## RE “NERINGAH” SENIORS HOUSING AND HEALTH FACILITY (SSD-45121248) SUBMISSION

We refer to the above State Significant Development Application (SSD) submitted by Hammondcare at No 2-12 Neringah Avenue South, Wahroonga (referred to as No 4-12 Neringah Avenue in the application).

We are writing on behalf of the Owners of **Strata Plan 100500** known as the “**The Sirius**” apartments at 14-18 Neringah Avenue South, Wahroonga. Our client’s property directly abuts the northern boundary of the subject site. Refer to **Figure 1** below.

DRAWING TITLE
Landscape Plan - Stage 2 Ground

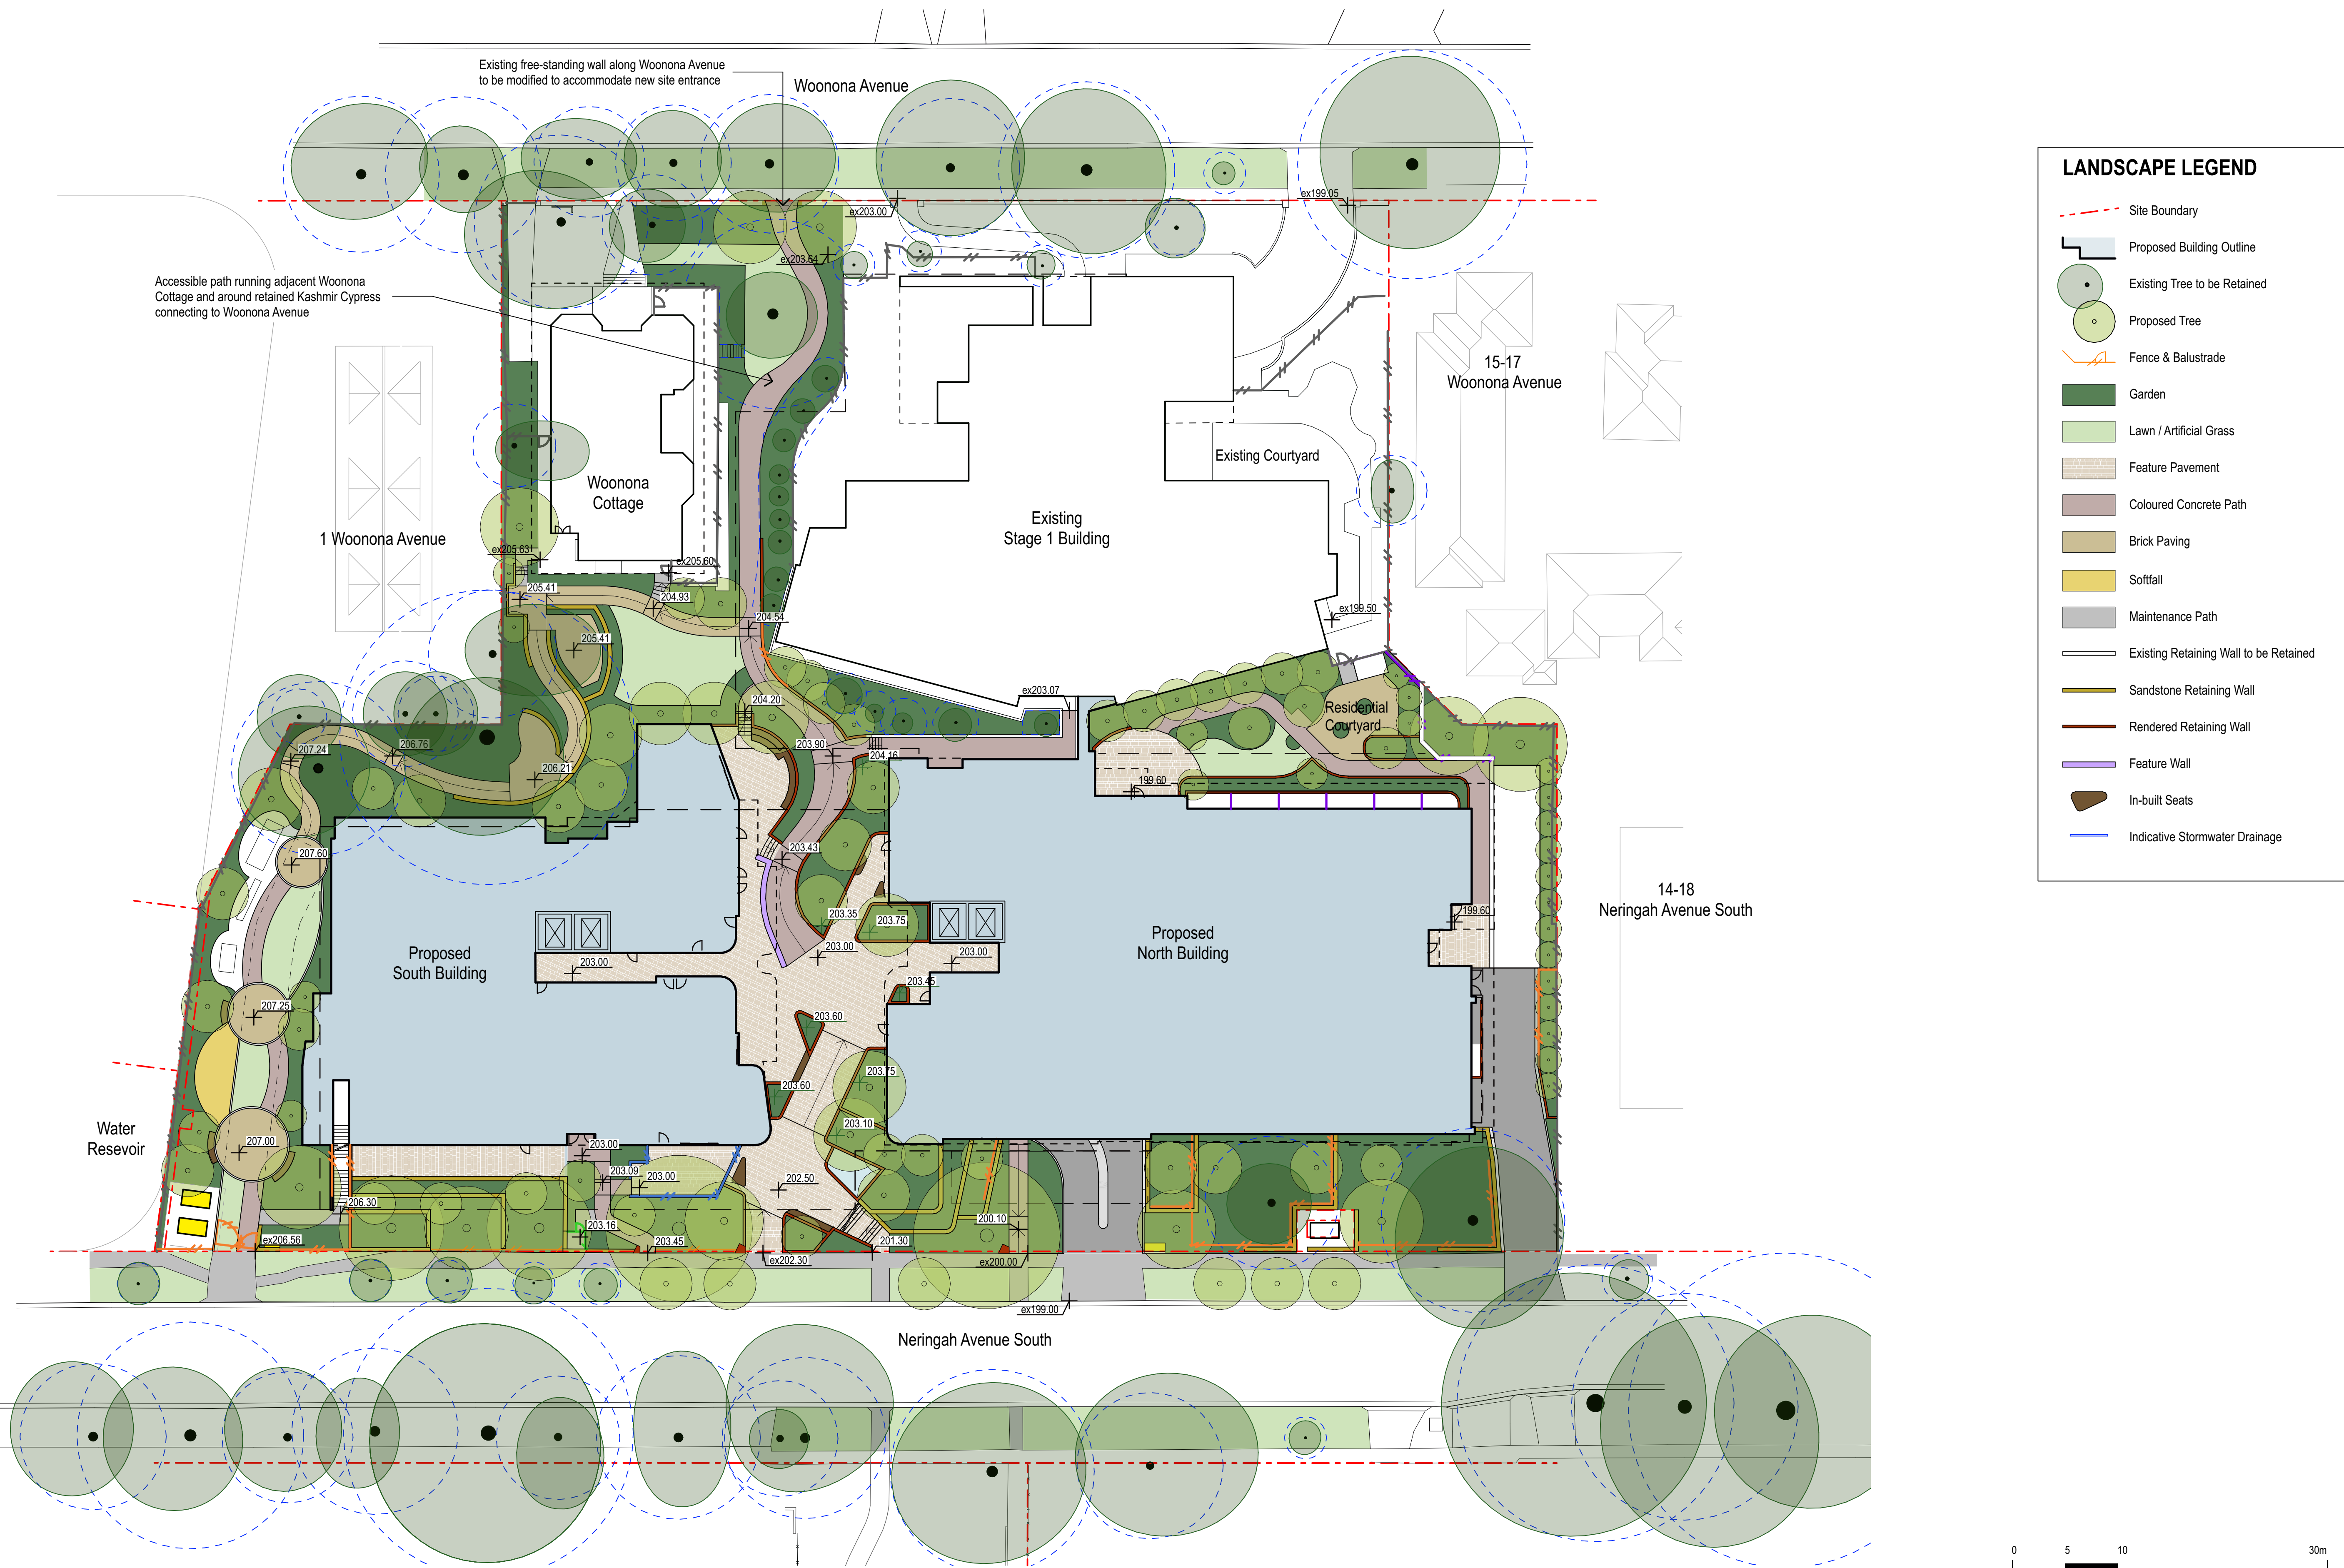
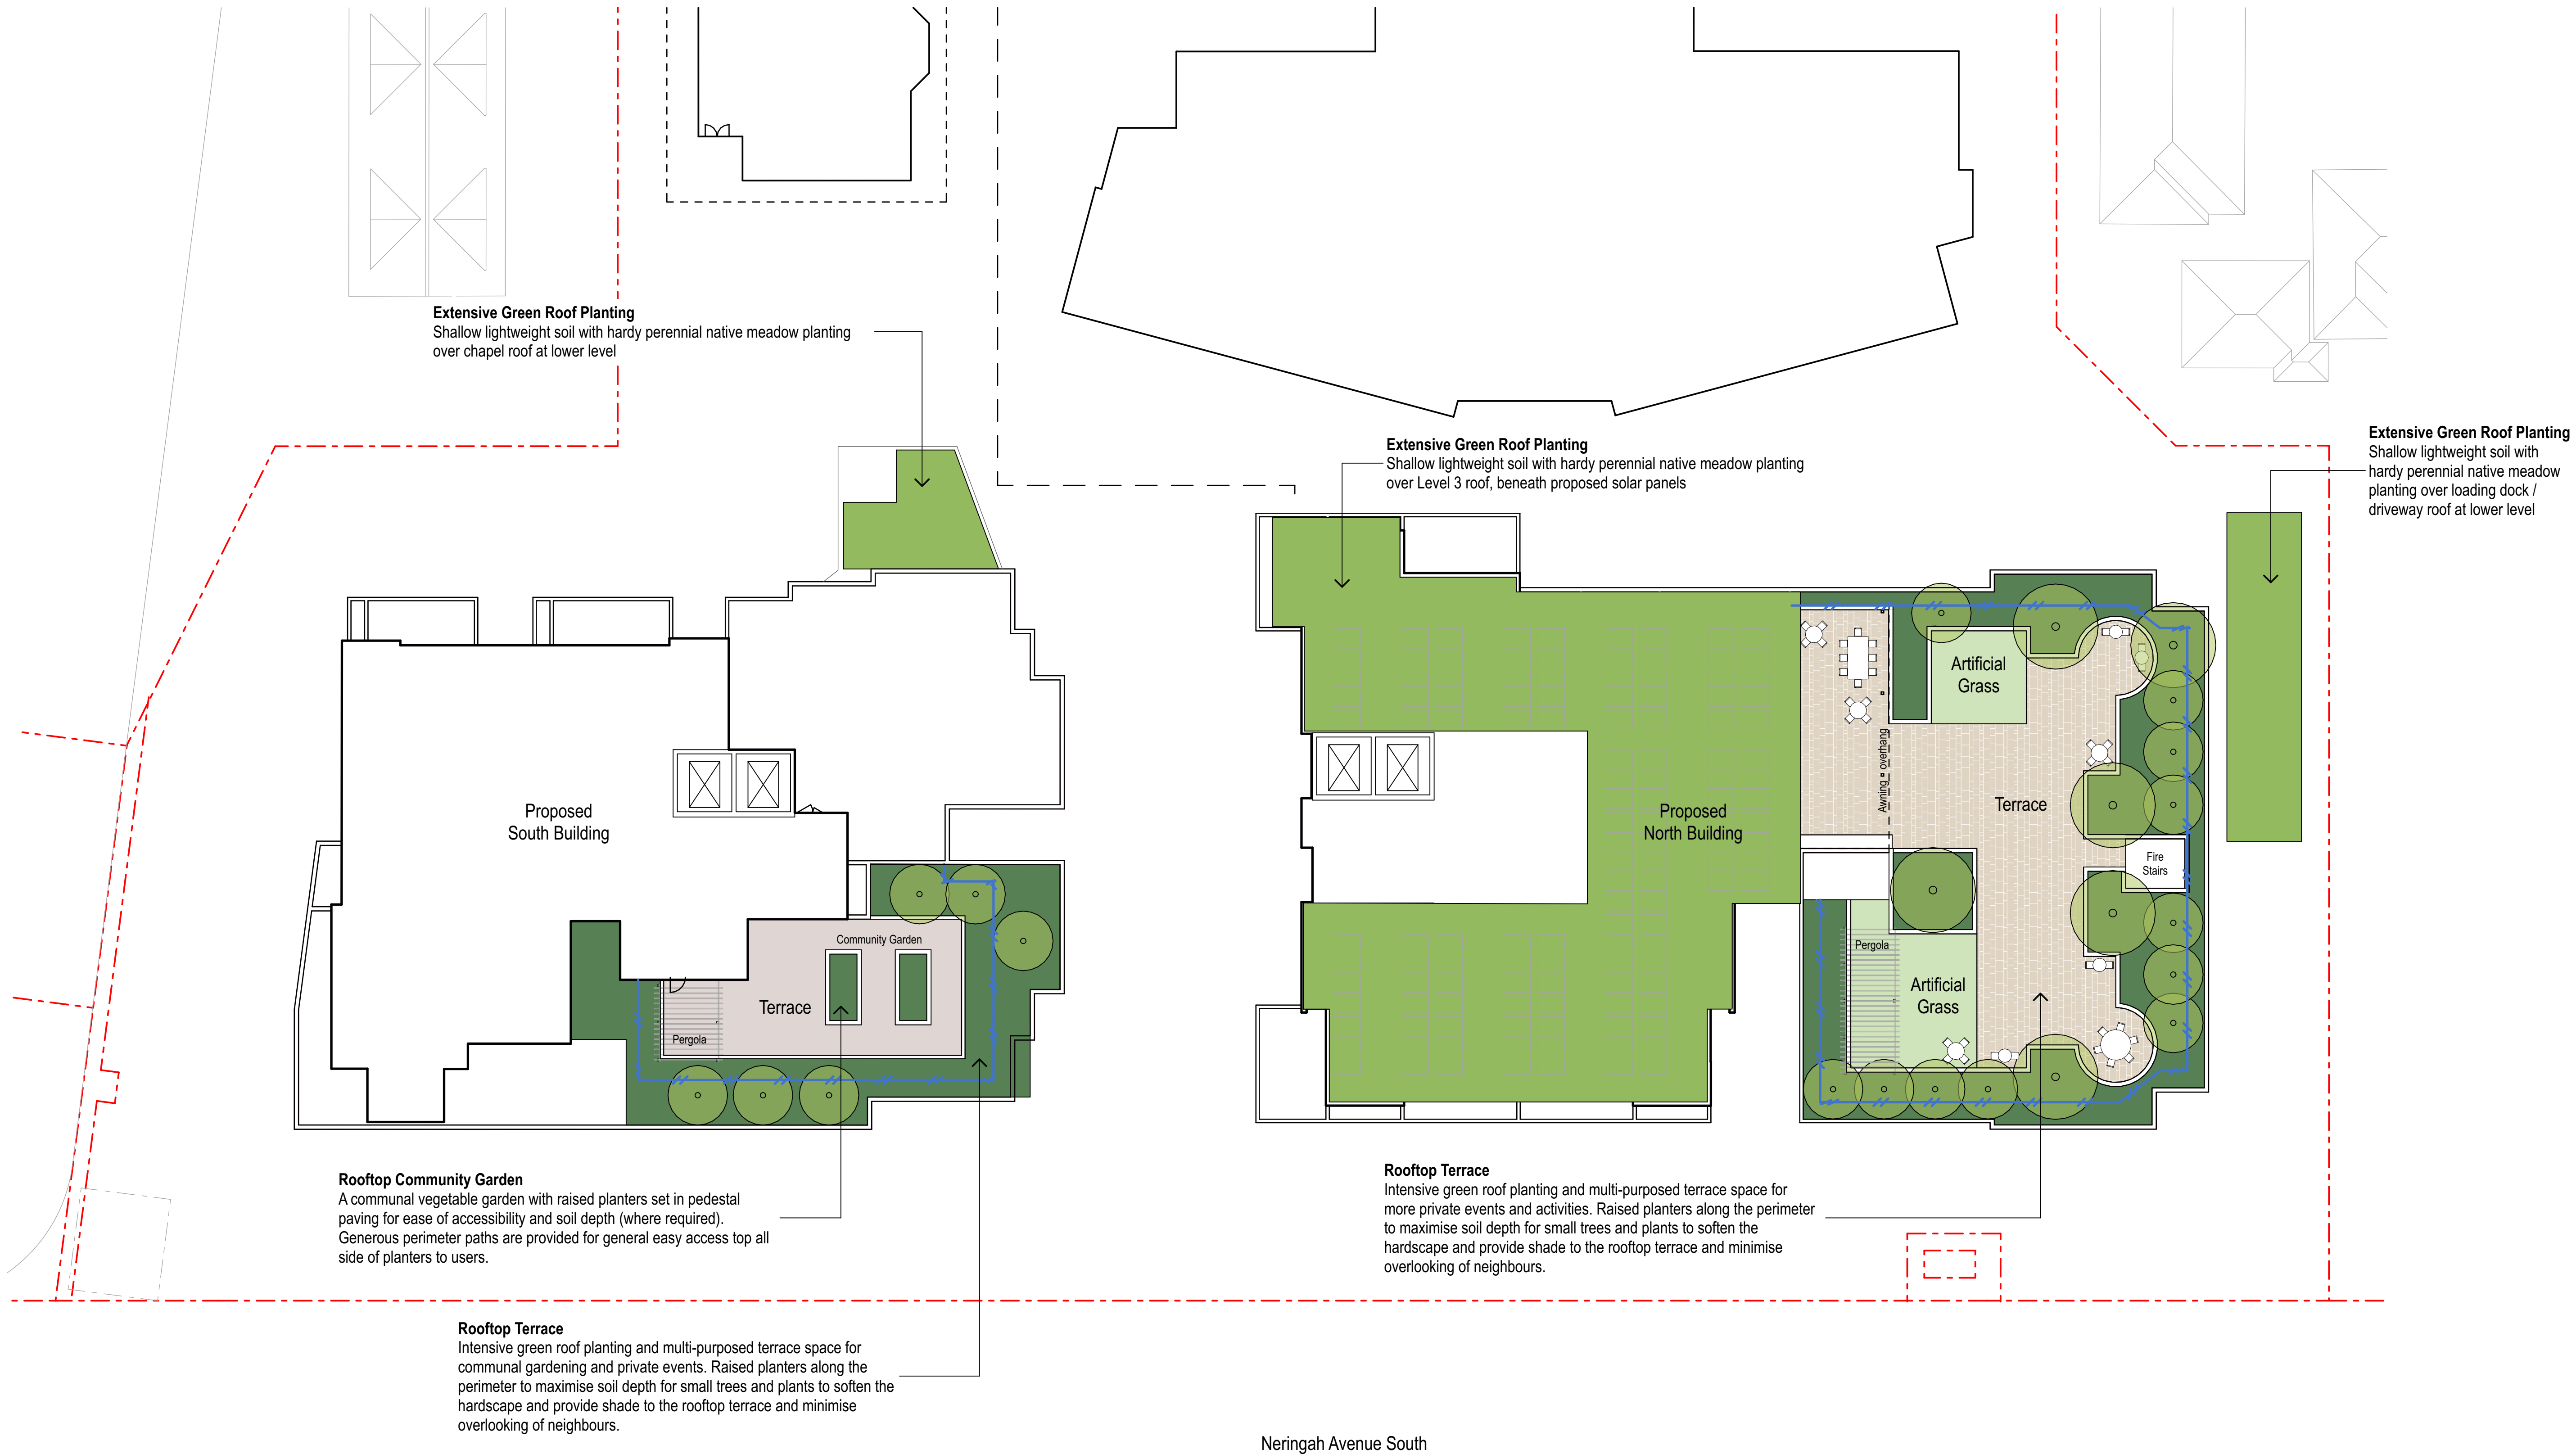
The proposed row of Blueberry Ash (45L pot size) typically have 4m wide canopy, so that the trees will be significantly constrained by basement walls and side boundary fencing. Access for tree and stormwater pipe maintenance within the 1.63m wide dimensioned space may also present practical challenges as the trees mature in the confined space.

- e. **Landscape Treatment:** - The basement entry structure “lid” is shown on landscape plans to comprise “*Shallow light weight soil with hardy perennial native meadow planting over loading dock/driveway roof at lower level*” as denoted in **Figure 8**. Hence the side setbacks behind the building line which are ordinarily 6metres wide deep soil planting zones to provide tall vegetative screening between RFB developments in Ku-ring-gai, is not provided to any meaningful/effective degree.
